Our Ref: NW/ARU/17/26/B

Date: 20th November.2017

RE:- Promenade Opposite Walton Avenue The Esplanade Bognor Regis PO21 1LX

Thank you for your correspondence of 14th December 2017, advising me of an application for the Demolition of the existing Foreshore office & decommissioning of existing underground toilets. New purpose built unisex toilet block including urinals, baby changing facilities & accessible WC, plus a separate beach office with public information point & first aid facilities. All located on the existing seafront promenade for which you seek advice from a crime prevention viewpoint.

DRAWING
Proposed Toilet Elevations

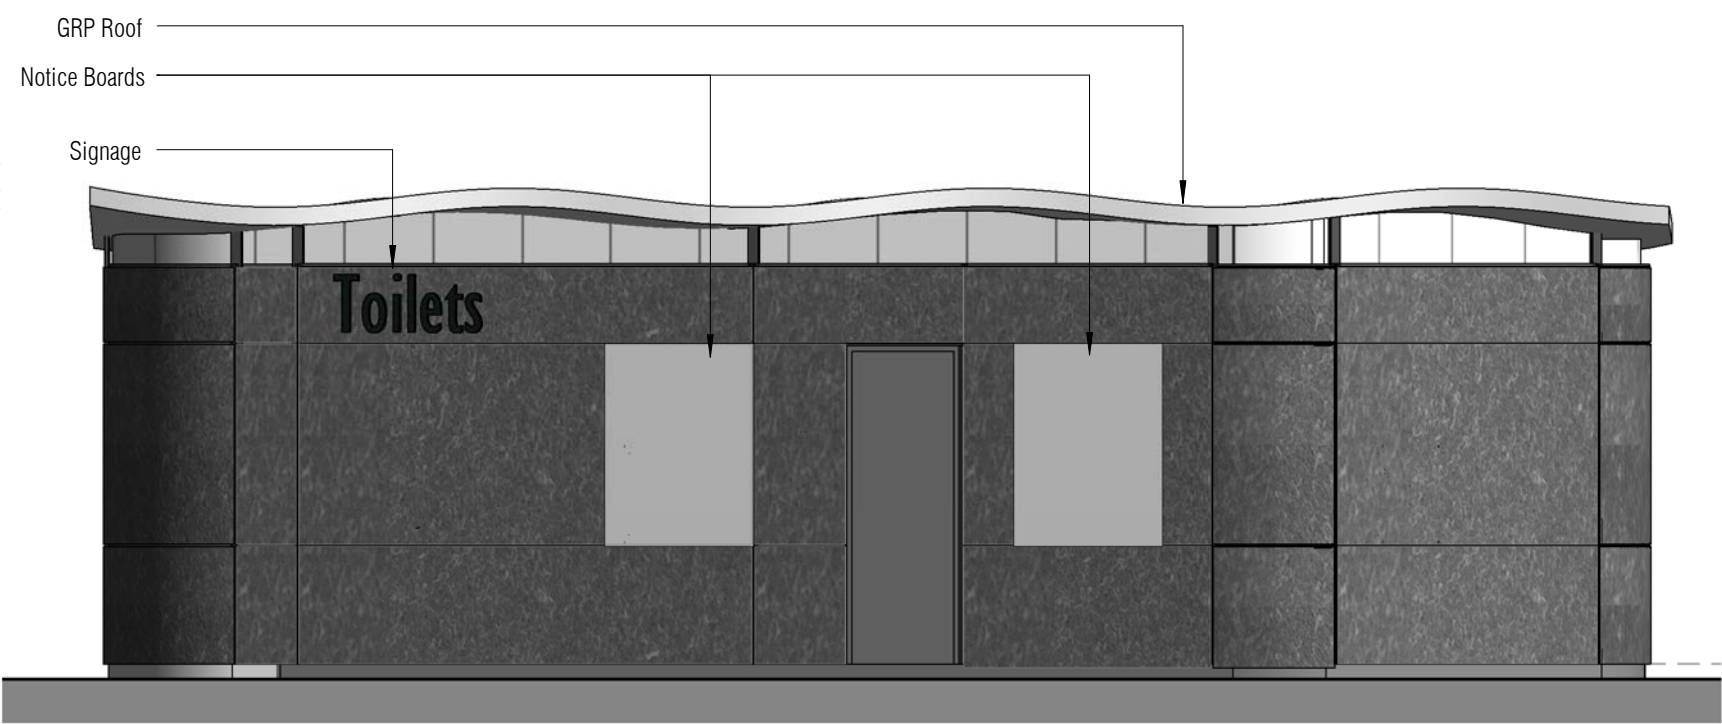
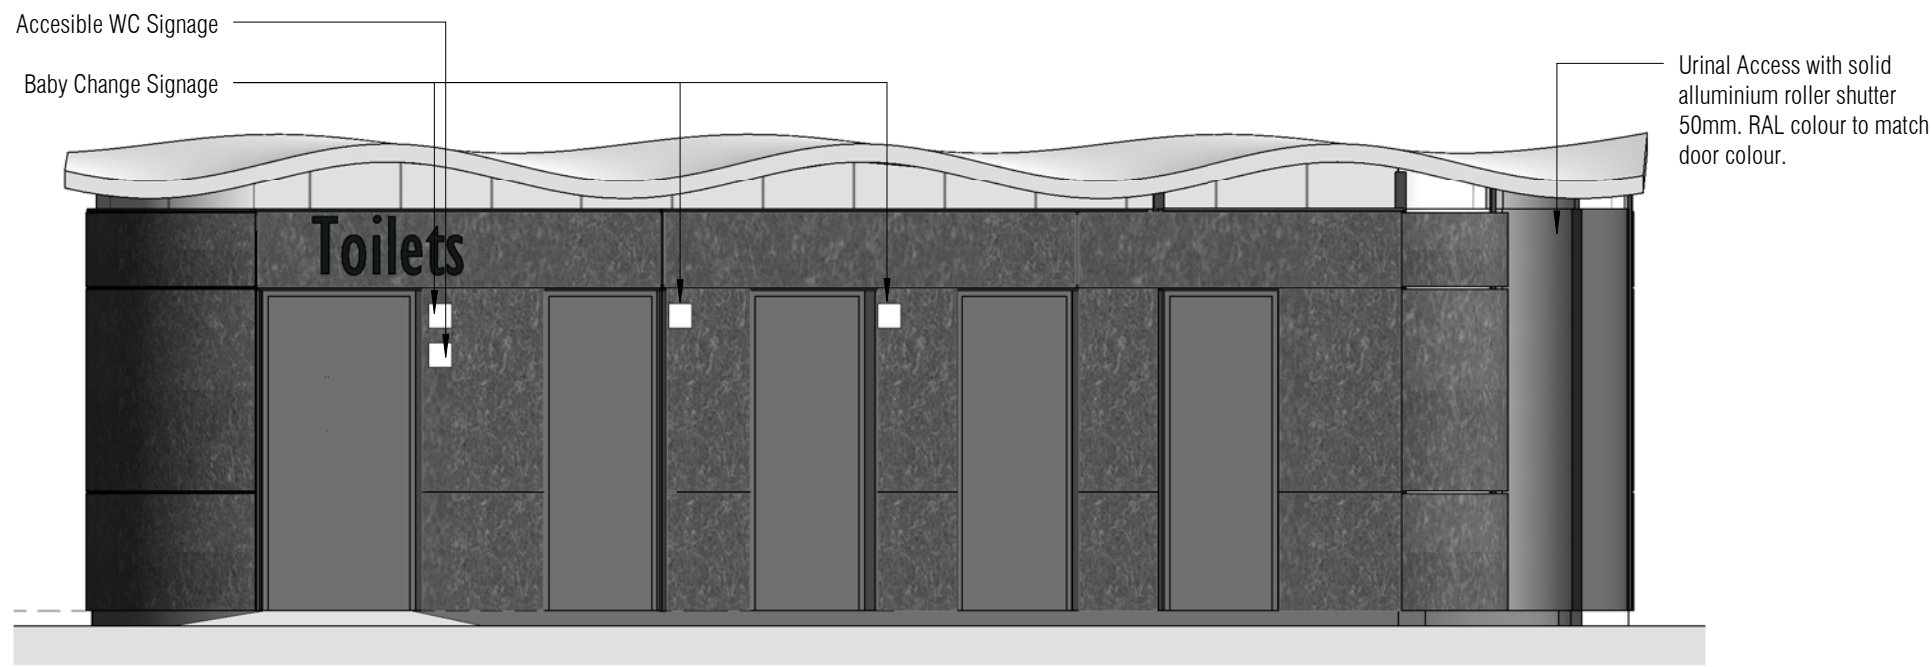
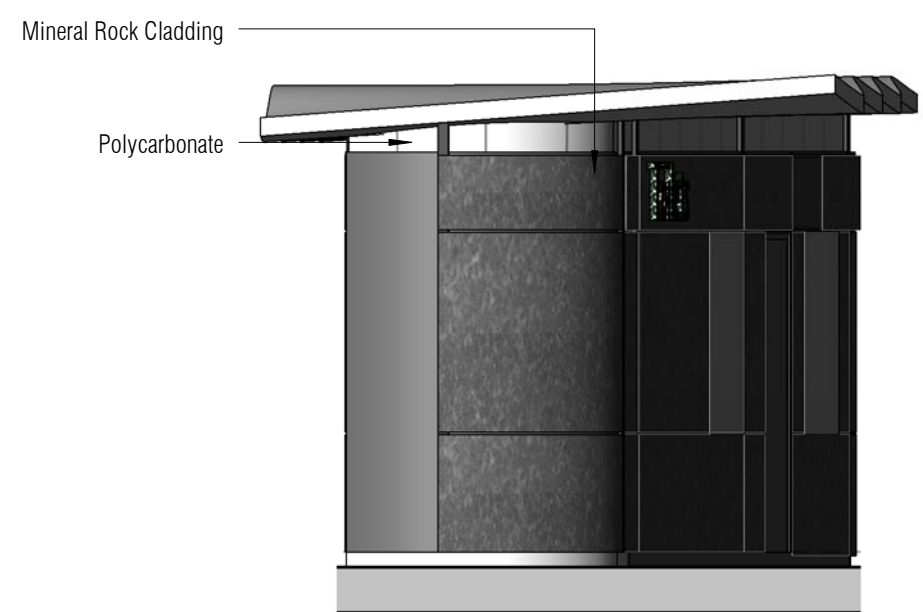
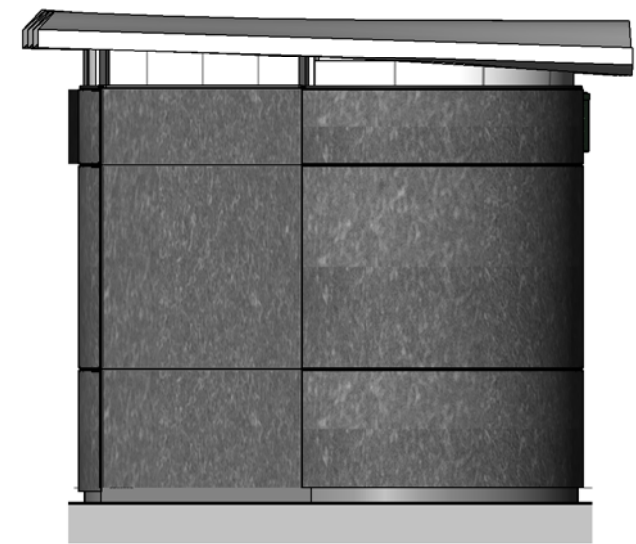
I am pleased to see that the orientation of the toilet block and beach office has been reversed so that all the toilet doors face towards the beach and offer natural surveillance, thus removing issues of person caught between open doors being subject to crime and unable to pass, or being struck by an opening door. Self-closing doors will also help prevent persons being struck by a flapping door in high winds.

DRAWING
Proposed Beach Office Elevations

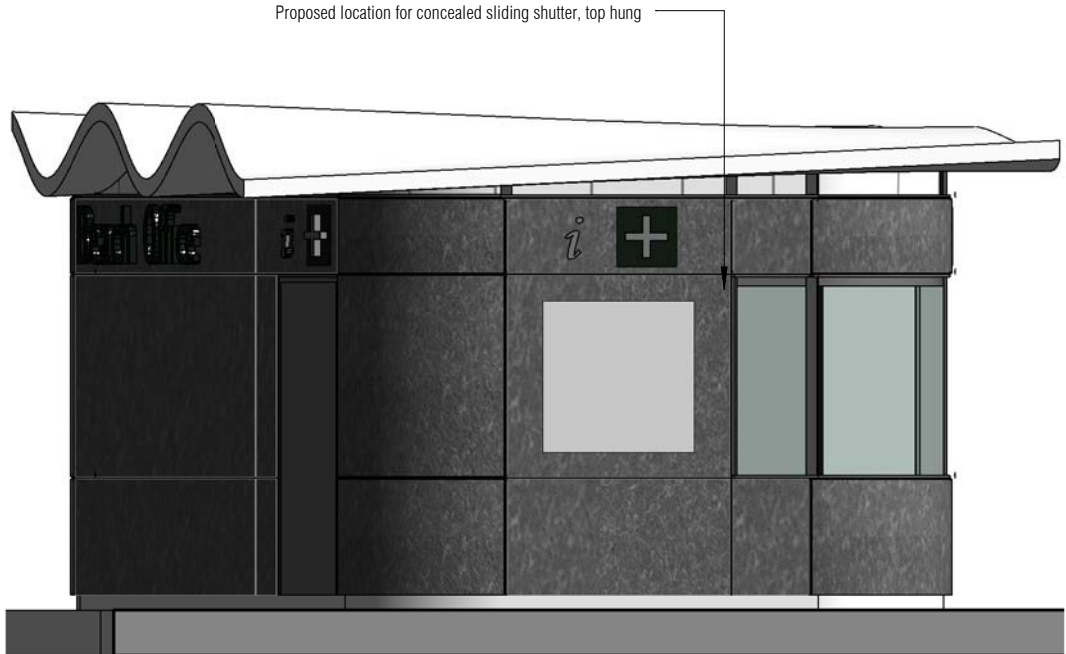
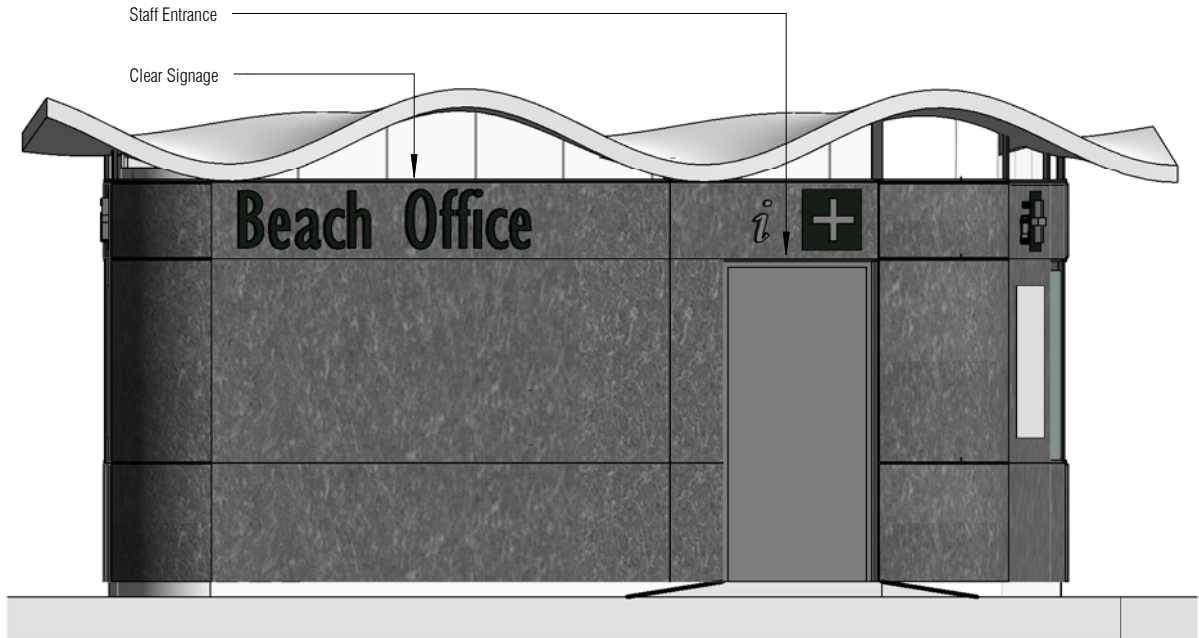
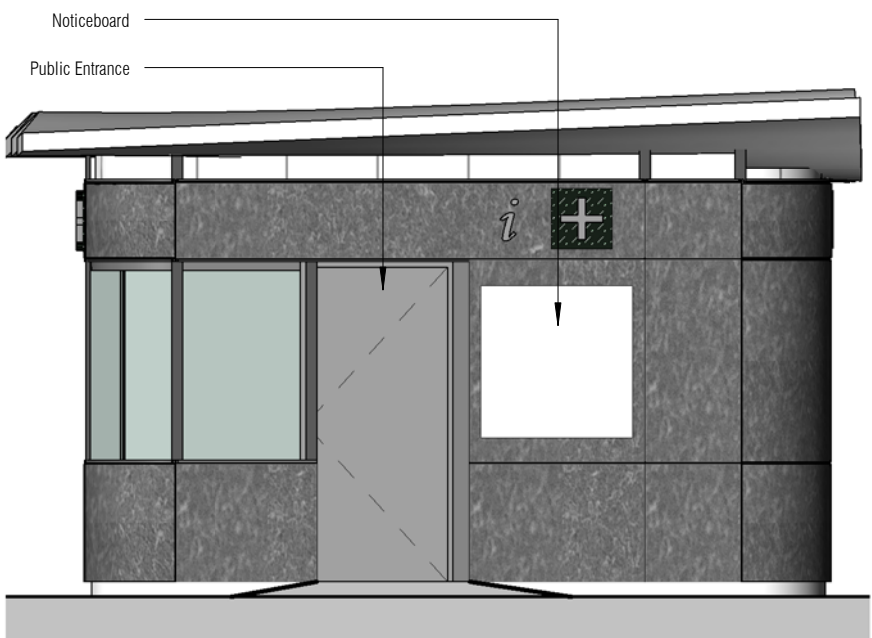
I would recommend the rear access doors to the toilet service area and also the beach office have a guard rail or post to prevent passers by being struck when the doors open and fitted door viewers would assist to see who is outside before opening the doors.
